MIDDLETON-ON-SEA PARISH COUNCIL

12th October 2020

Re: Planning Application M/68/20/PL–Poultry Farm 87, Yapton Road Middleton-on-Sea – demolition of the existing structures and redevelopment to provide a new 66 bedroom care home arranged over two storeys together with associated access, car and cycle parking, structural landscaping and amenity space provision, (resubmission following M/80/19/PL). This application is in CIL Zone 4 (Zero Rated) as other development.

Figure 2: access arrangement for extant residential scheme at the site.

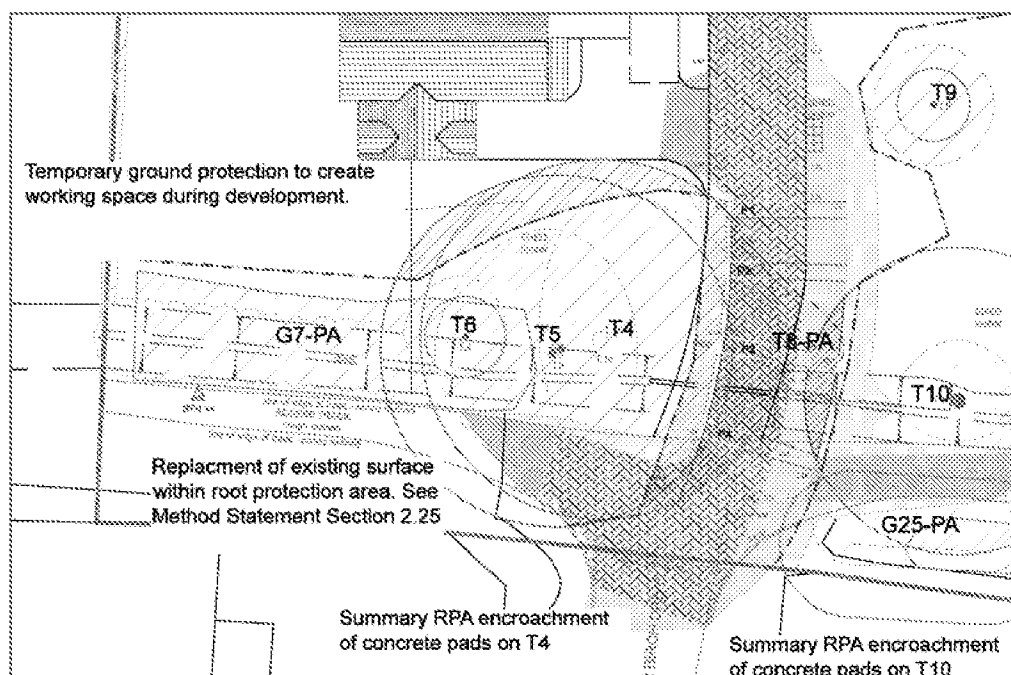
- 2) The use of the proposed access will result in damage to the protected Ash Trees by virtue of the proximity of vehicle movements to them, leading to their loss contrary to policy ENV DM4 of the Arun Local Plan.

- **Response to the above by the applicant of planning application M/68/20/PL**
The planning statement presented with this new application states that the applicant does not accept this and has therefore made no attempt to assist in resolving this issue, so the refusal by Arun District Council on this point would still exist.

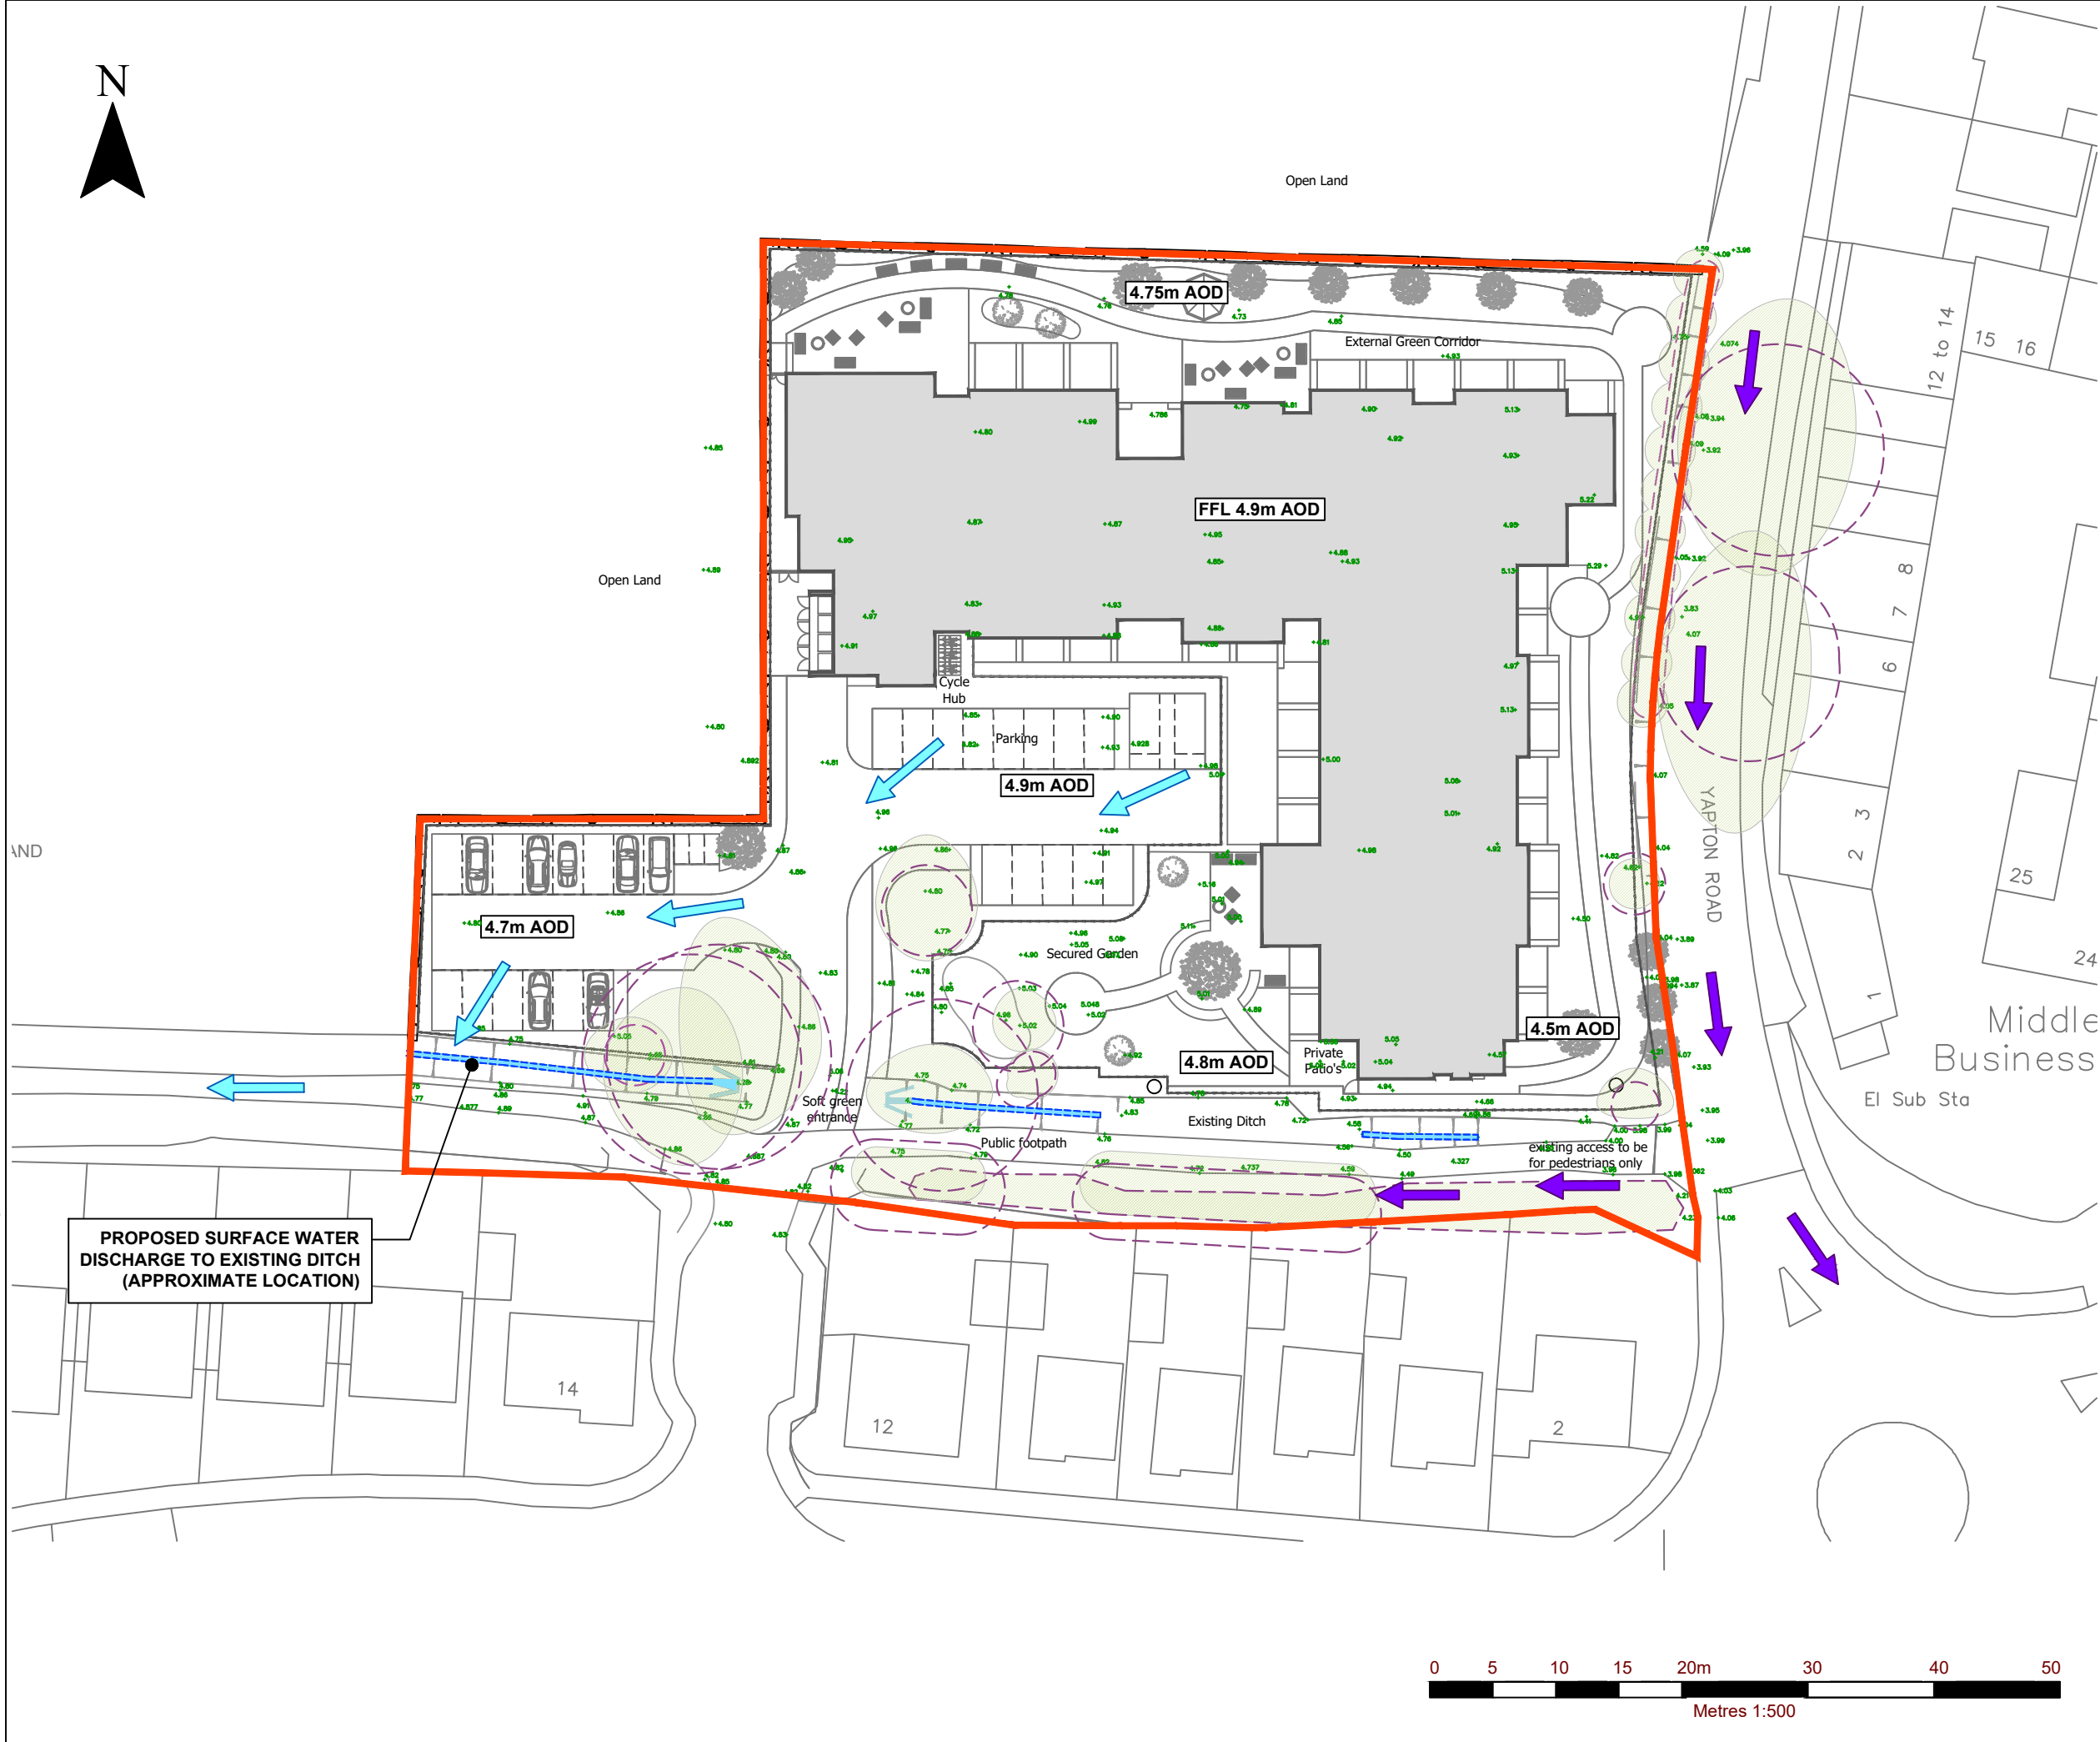
- **Foul & Surface Water Drainage**
 - Surface water flooding is a concern if no significant improvements have been made or will be made so that the flooding issues in 2012 are not repeated

- The surface water overflow with high rainfalls will flood the roads and nearby properties.
- **Risk of Flooding**
- The area of the proposed development is shown to be within an area of high risk from groundwater flooding.

- This area has flooded six times between 1963-2014 with 2012 seeing Yapton Road and surrounding areas being flooded to a depth of 1 metre
 - We have concerns that with the new basement area the risk of flooding in the area will increase and will see local roads flooded and we need Arun DC Drainage department to advise as to the probable risks that this may cause over an area that floods on an annual basis
